Town & Country Planning Act 1990 (as amended)
Town and Country Planning (Development Management Procedure) (England) Order 2015
Application for approval of details reserved by condition imposed under planning permission
BN/7/18/PL relating to condition No. 3 (proposed surface water drainage), 4 (Discharge of
watercourse) & 5 (Surface water drainage system)
Land to the north of The Flint Barn Yapton Road, Barnham,

Arun District Council have decided to **REFUSE details reserved by condition for the following reasons:**

Engineers Comments Regarding Conditions 3, 4 and 5

Drawing:
Drainage Strategy

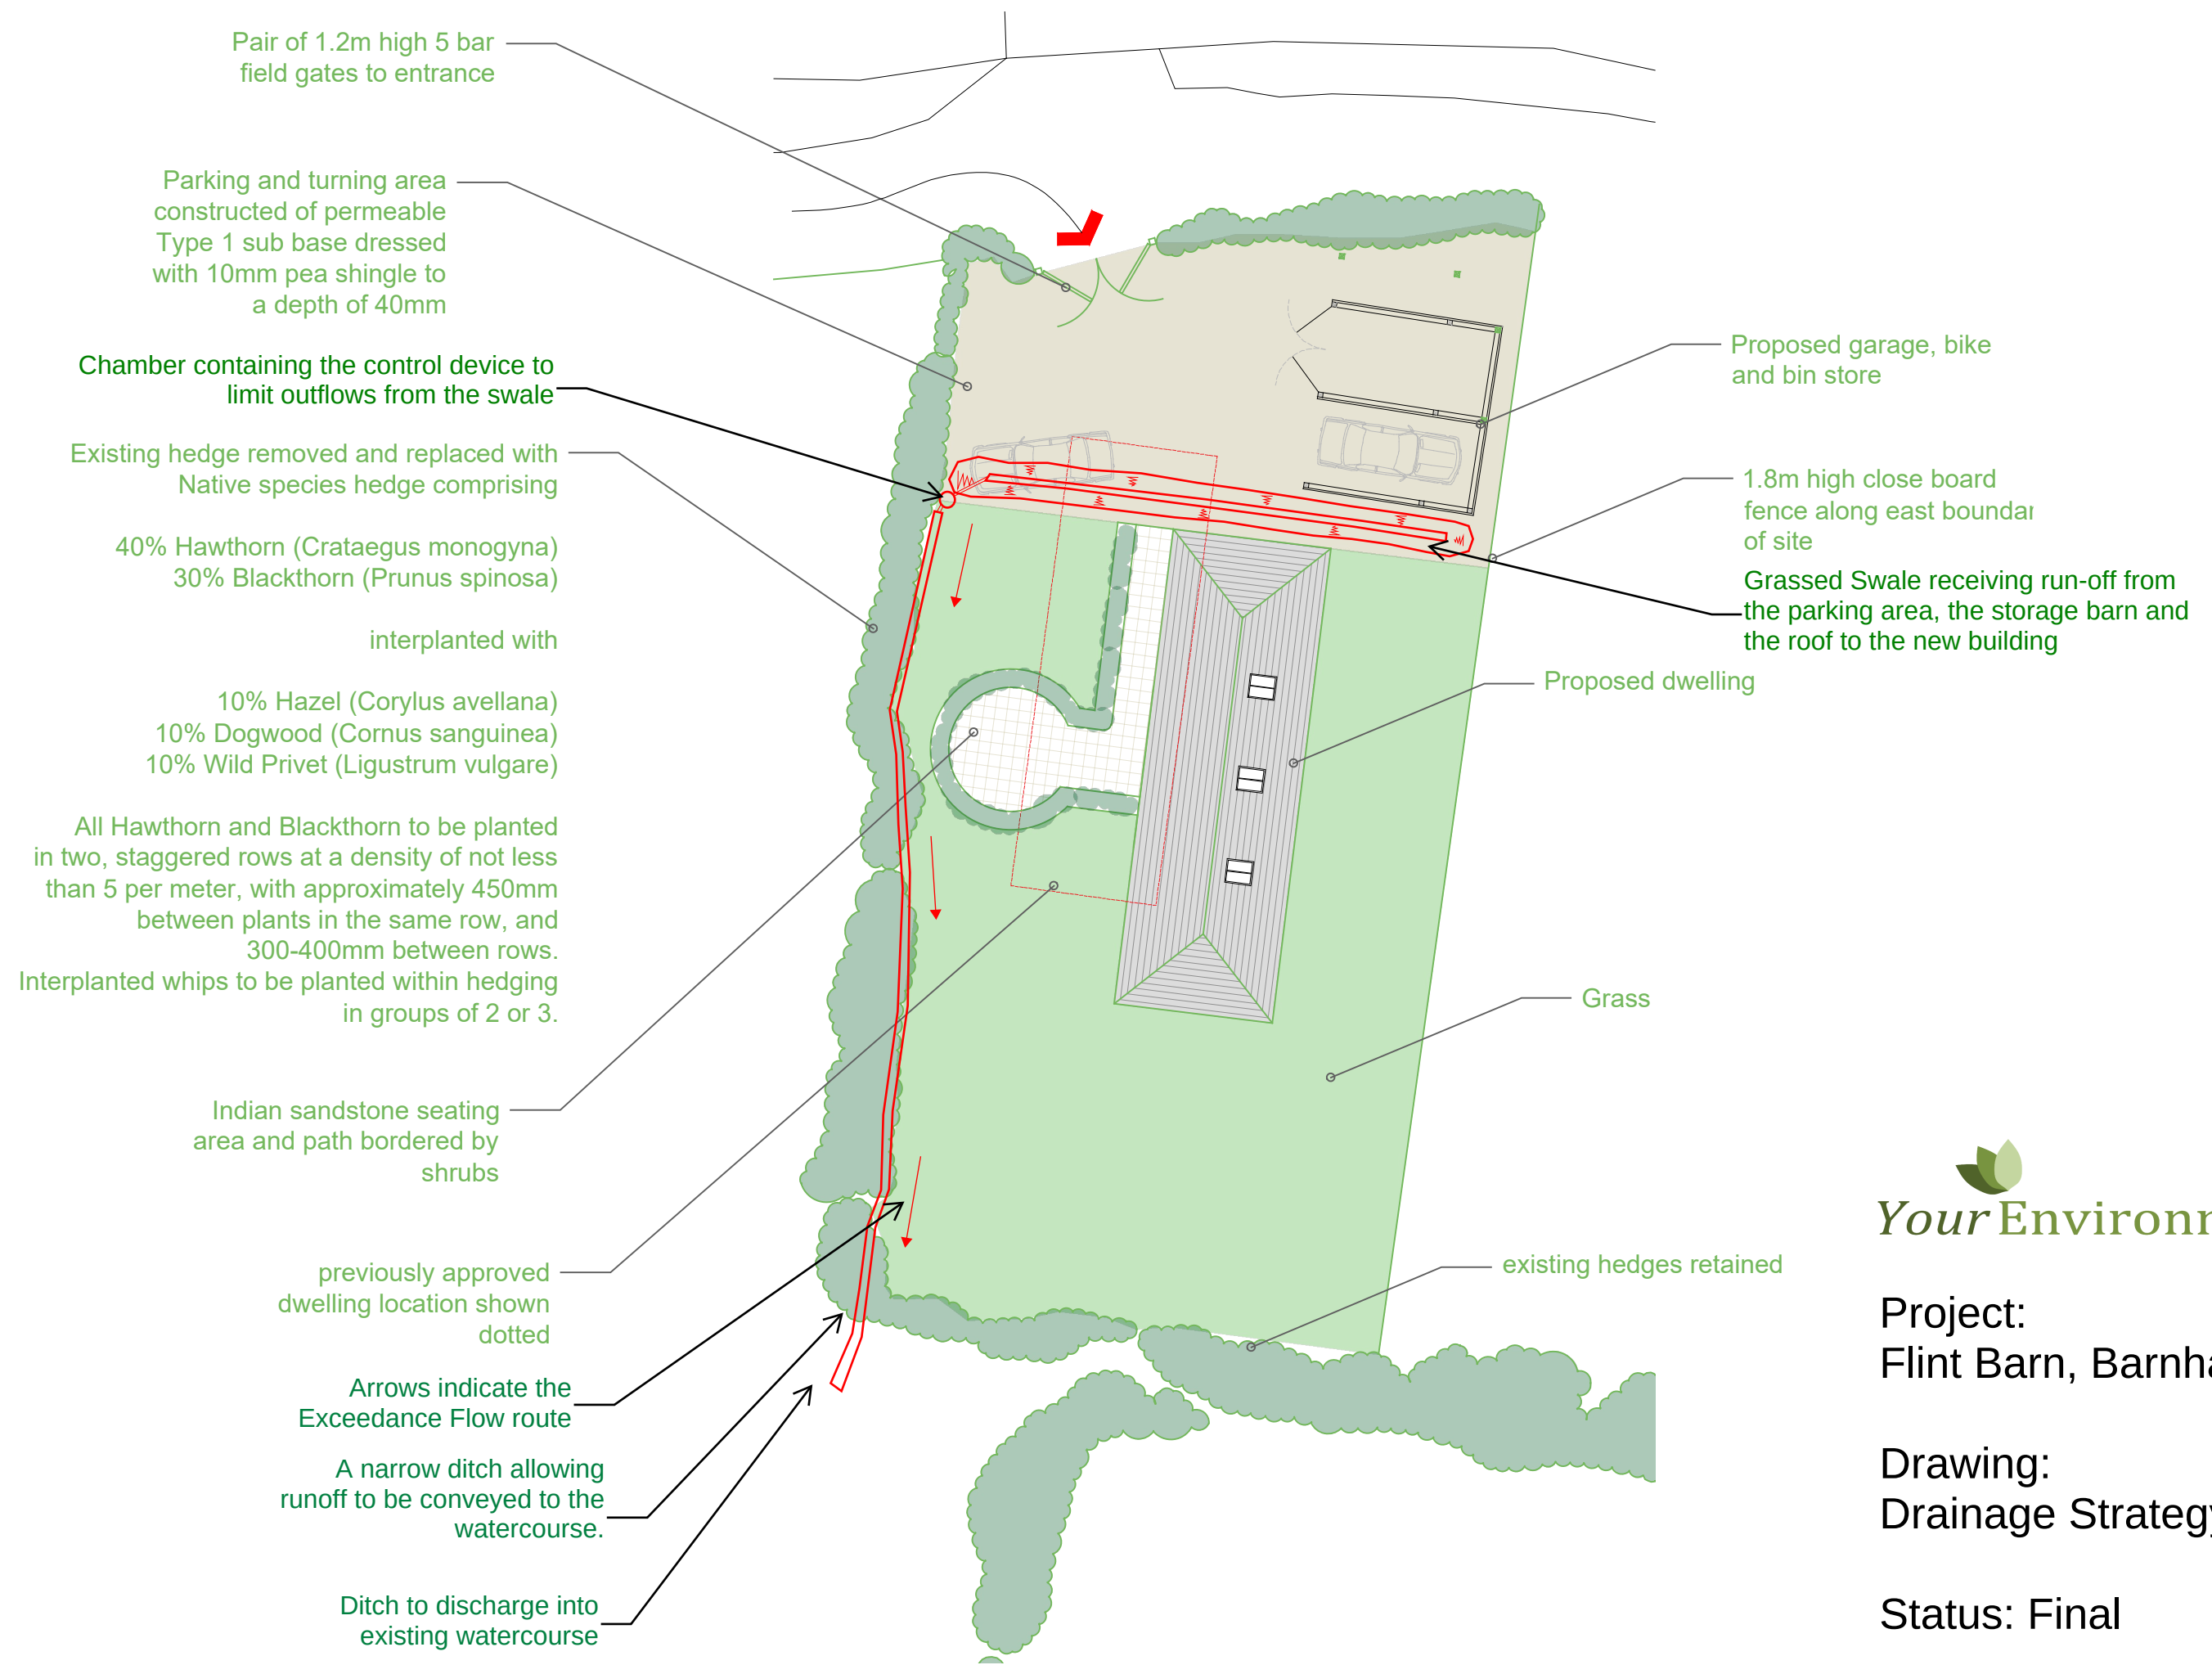
The applicant proposes to form a new swale and connect this into an existing ditch which runs to the south of the site. Winter groundwater monitoring was completed in March, which found ground water levels to be high. We believe groundwater would have peaked before March, therefore may be higher than those levels recorded and we agree with the conclusion that infiltration is unlikely to be viable. However, the applicant may wish to investigate shallow permeable paving solutions. The proposals currently include for the storage of the 1 in 30 year rainfall event on site. Please revise the plans to accommodate the 1 in 100 year plus 40% climate change event on site. Please also clarify the rate of discharge proposed, orifice diameters have only been provided. In order to discharge flows to an ordinary watercourse the applicant will need to obtain Ordinary Watercourse Land Drainage Consent, (the consent forms will be forwarded separately). I have inspected the watercourse which the applicant proposes

on discharging into, it is heavily overgrown. The condition of this watercourse will need to be improved to ensure that flow can be conveyed downstream. The watercourse is culverted and runs under Yapton Road, the condition of this may also need to be reviewed.

Until such a time as consent is obtained and the above points are addressed I do not recommend that these conditions are discharged.
